SUBSURFACE WASTEWATER DISPOSAL SYSTEM APPLICATION

Street or Road: 380 Pleasant Avenue

Replacement System Variance Request

SUBJECT: Approval, Replacement System Variance Request, Axiotis property, Peaks Island

SUBSURFACE WASTEWATER DISPOSAL PLAN

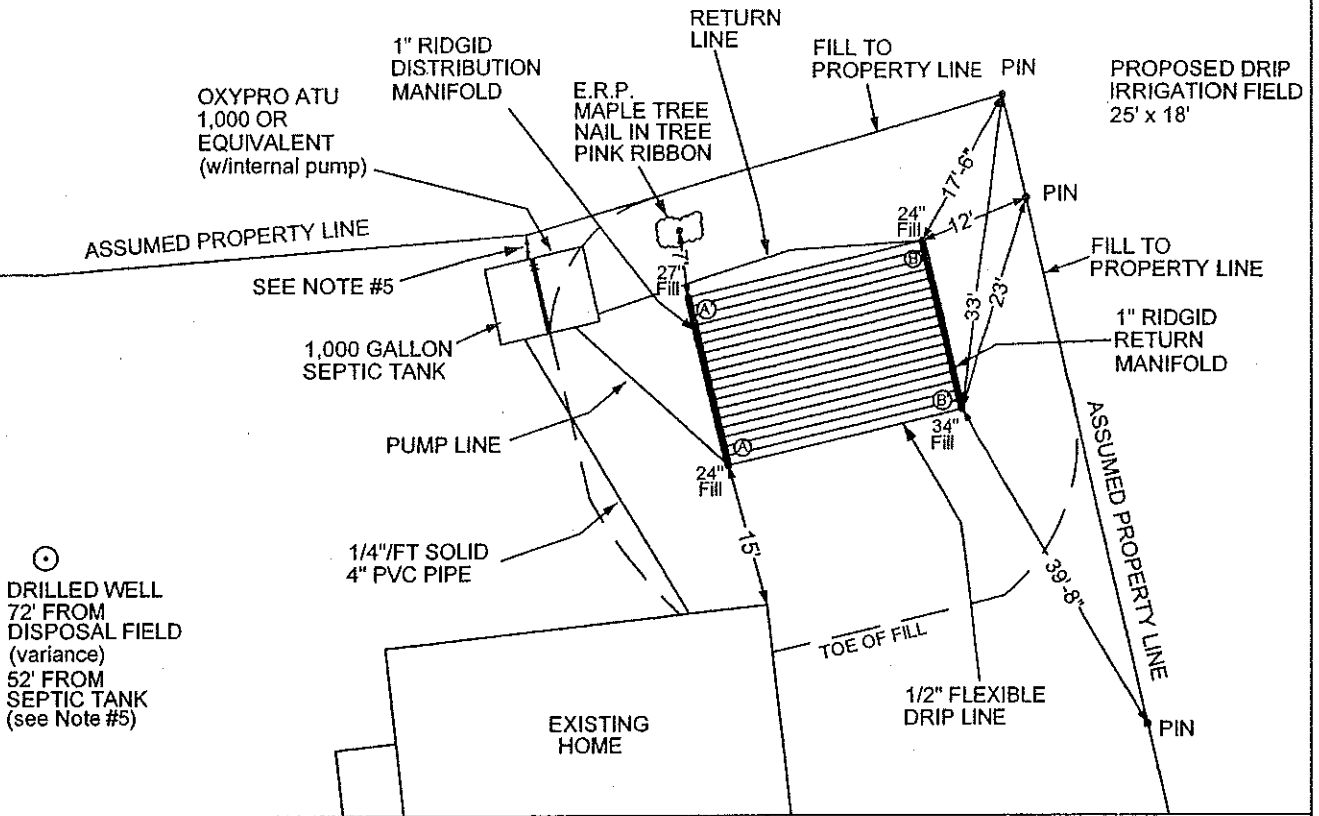
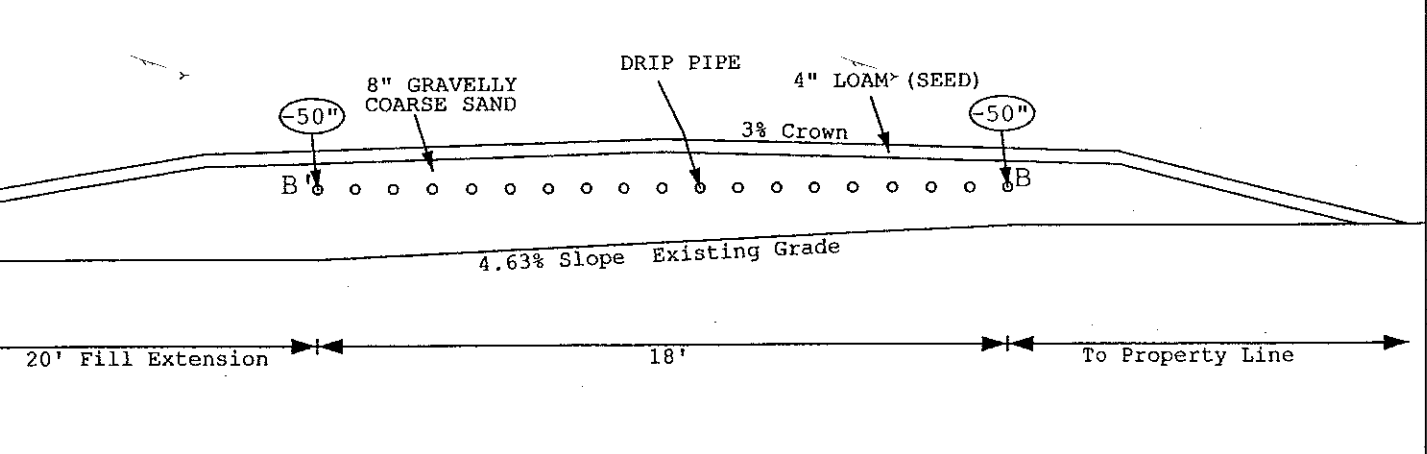
Comments: No PRACTICAL LOCATION FOR TANK

The Division has reviewed a replacement system variance request for the subject property. The state variance requested is to install the system with a setback distance reduction from your well to the disposal field of 72 feet, a setback distance reduction from a slab, frost wall, or columns to the disposal field of 14 feet, a setback distance reduction from a property line to the septic tank of 0 feet, a reduction in depth to the seasonal high ground water table from 12 inches to 0 inches, a reduction in depth to bedrock from 24 inches to 1 inch, and a fill extension grade to 3:1 as needed to keep fill from crossing the property lines. As we understand the situation, the variance request has been submitted because topography and existing development limit the potential system location. The system design prepared by Andrew Gobeil, SE, dated 09/18/2005 is otherwise found to be in compliance with the Maine Subsurface Wastewater Disposal Rules.

We approve the requested variance with the following requirements:

1. A permit for system installation is to be obtained from the Local Plumbing Inspector in advance of the start of system construction.
2. The system is to be installed in accordance with the submitted and approved system design. Should alterations to the design be required at the time of construction, the site evaluator is to be notified prior to making any changes.
3. The contractor is to scarify the soils under the fill extensions to create a transitional zone more compatible with the disposal field area.
4. The septic tank to be installed shall be monolithic.
5. No fill shall cross over the property lines unless a legal easement is granted by the abutting property owners.
